Your ref
Our ref TL /3/2013/0169
Date 25th April 2013

Planning application no: 3/2013/0169

Proposal: 29 unit housing scheme (9 apartments, 17 houses, 3 bungalows) with associated parking, landscaping and highway works.

Location: Pendle Garage, Clitheroe Road, Barrow.

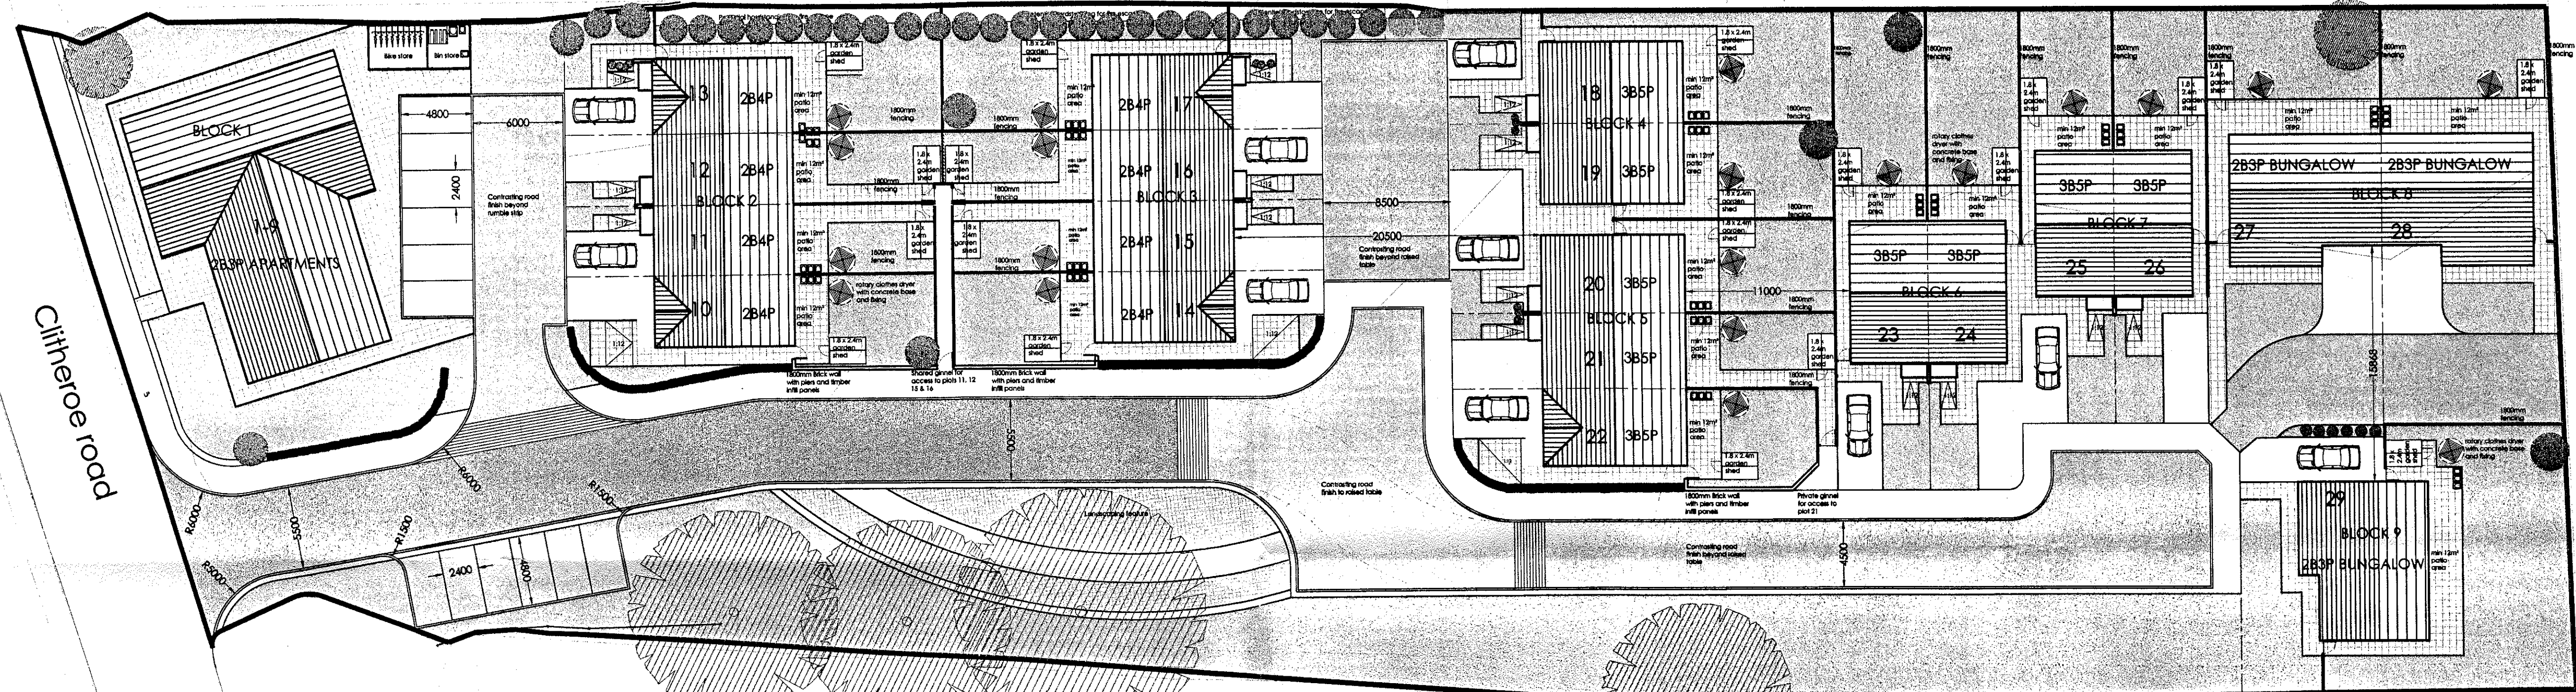
For these two and three bed dwellings, I would ask for 2 on-site parking spaces per dwelling. The proposals appear to be 33 parking spaces for 29 dwellings which is significantly less than my requirements. I am concerned that the estate road will not be able to accommodate the parking generated by this development, for which no on-site provision is made, and residents will be forced to park on Clitheroe Road. This will be to the detriment of highway safety and I would therefore recommend refusal of this application as submitted.

There are six parking spaces proposed south of the estate road opposite the apartment block. The status of these parking spaces is not clear as to, for example, who would maintain them. Also there is no obvious pedestrian access to these spaces. I would recommend that these parking spaces should be deleted.

The end turning head on the estate road at plot 29 should be checked for the tracking of a refuse vehicle.

Clitheroe Road here is a 40mph road and the visibility required would be 2.4m by 90m in both directions. The developer should show that this visibility can be achieved.

The proposed site plan shows a footway along the Clitheroe Road frontage of the site. This is required and should be at least the same width as the existing footway along part of the road frontage. In addition drop kerb disability crossings should be provided here on both sides of the carriageway, and paid for by the developer.

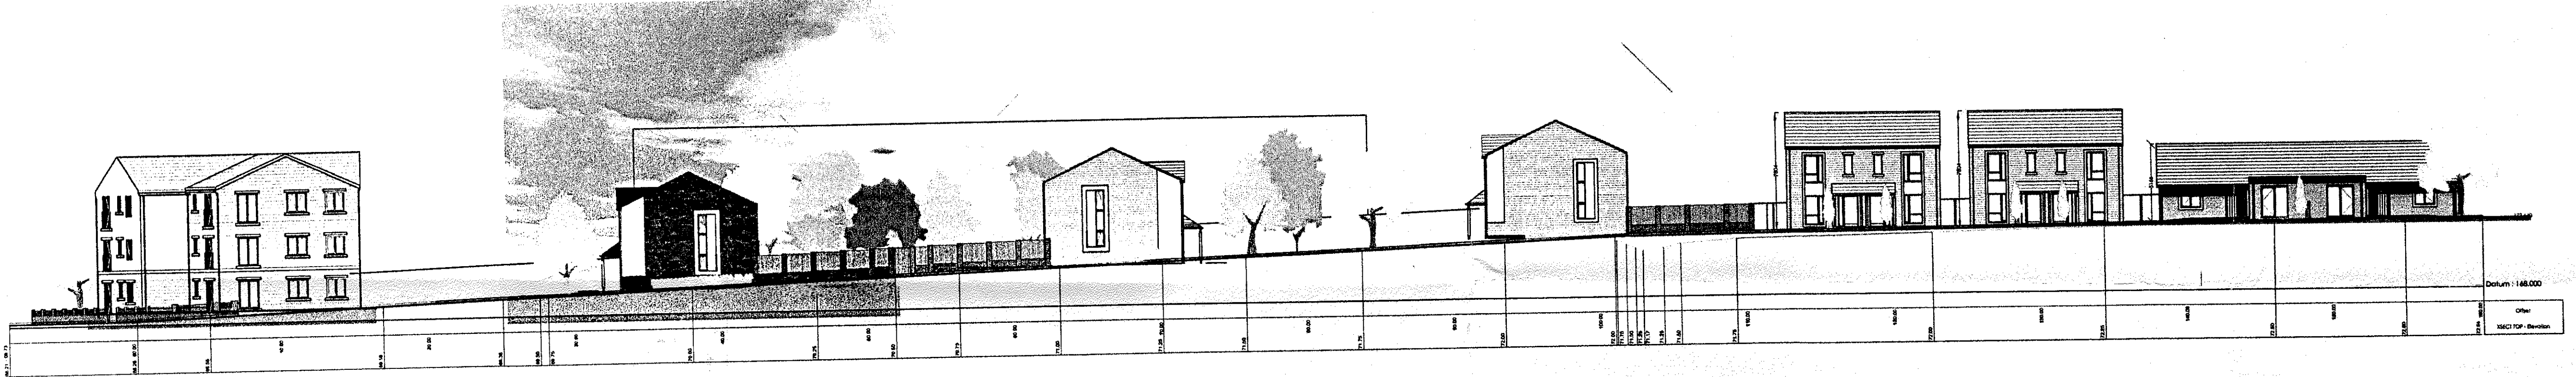
Some of the road frontage boundaries of the residential gardens are 1.8m high. Please ask the developer to reduce the boundary wall height to 1.2m as recommended by MfS.
